A57 Link Roads

TR010034

**9.6 Comments on other written
submissions received after the
registration of Interested Parties closed
on 16 September 2021**

December 2021

Insert 2 High Peak AADT Flow 2025

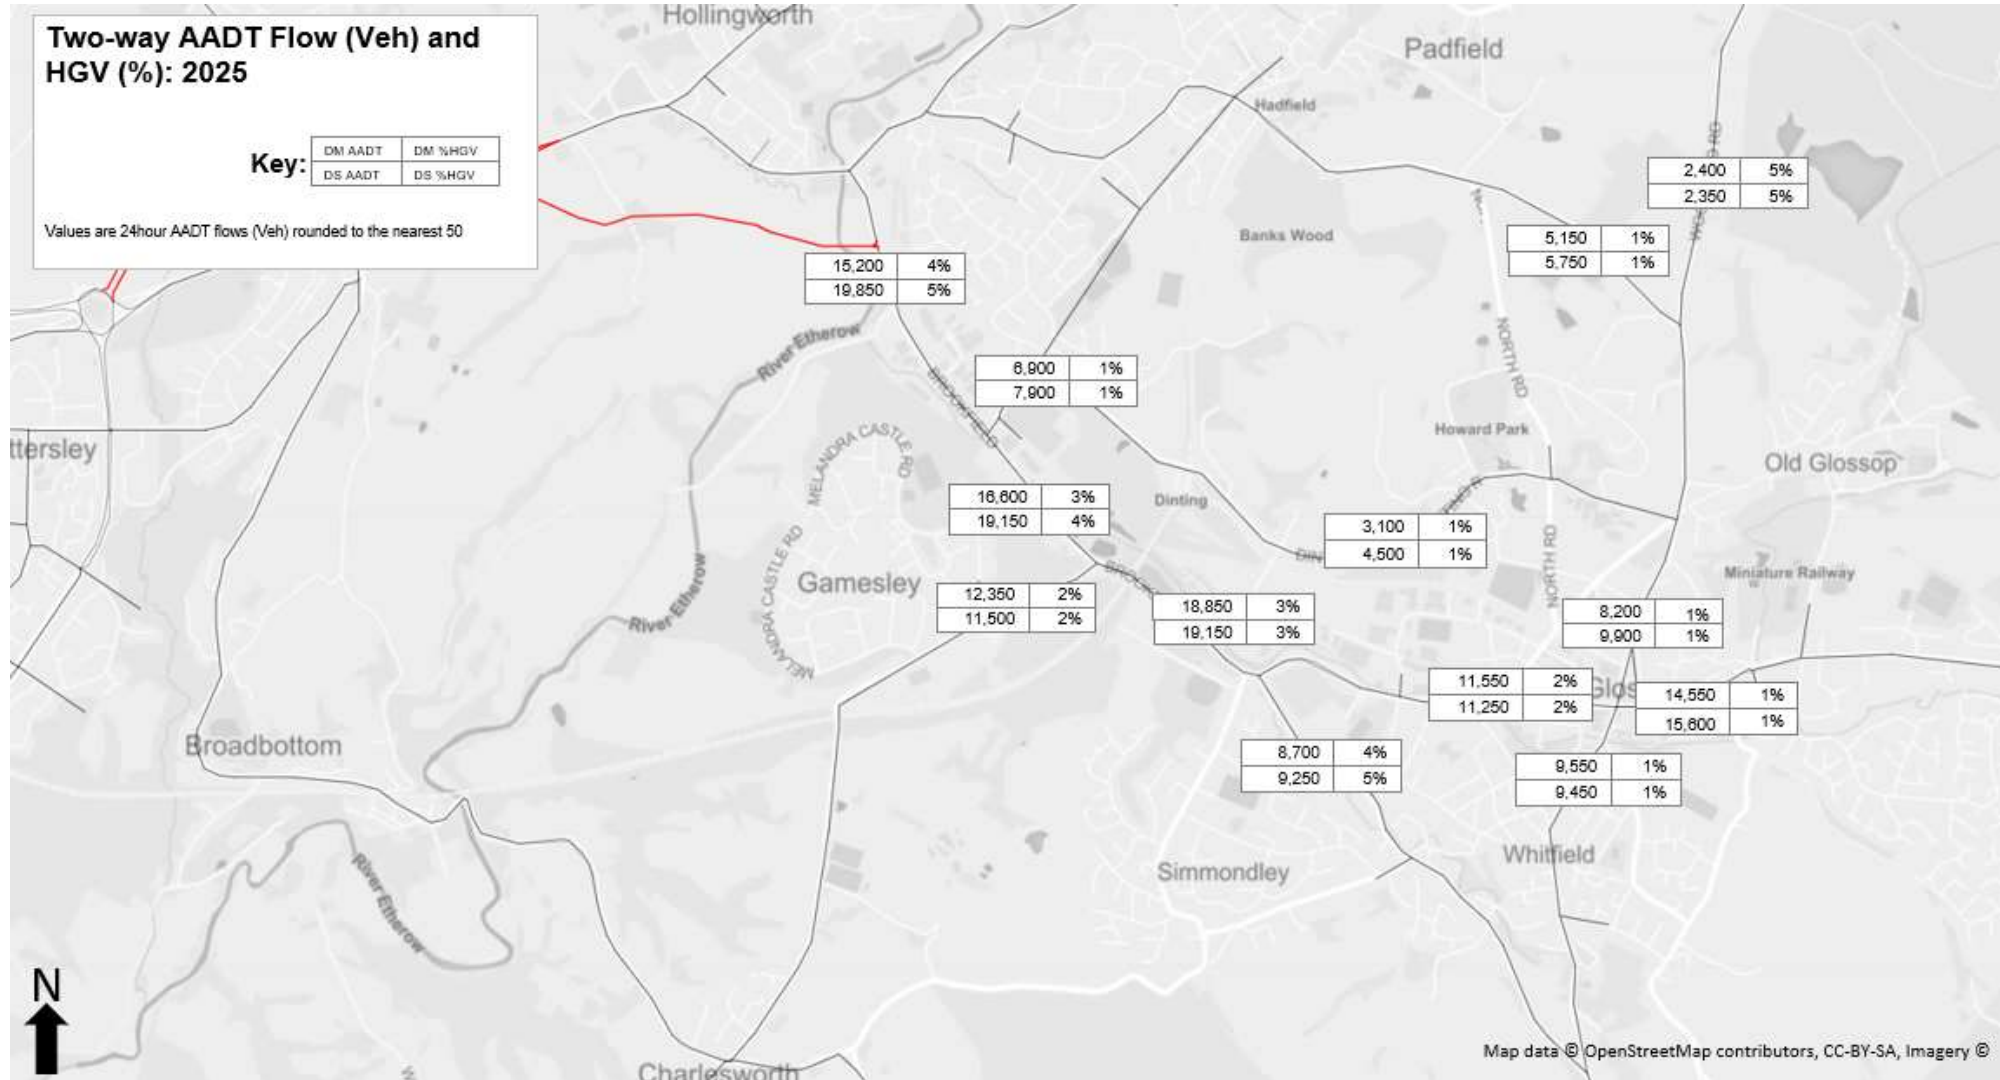
- 4.1.1. *I seek greater clarity regarding the derivation of the traffic model data, to assist my further written representation. Accordingly I submit this question of clarification to the Examination Preliminary Hearing.*
- 4.1.2. *"It is not clear what percentage of the promoter's modelled traffic data accounts for that generated by the "committed developments" (ES 6.4 Figure 15.1). Can the promoter Highways England please supply that figure both generally; and particularly with regard to the Glossop and High Peak figures? (HE Appendix 2.1 Inserts, 2, 3, and 11)."*

- 4.2.1. National Highways anticipates that there will be an issue-specific hearing covering traffic and transport, including traffic impacts on the local road network.
- 4.2.2. The traffic modelling undertaken for the assessment of the Scheme takes account of the available practical capacity of the road network.
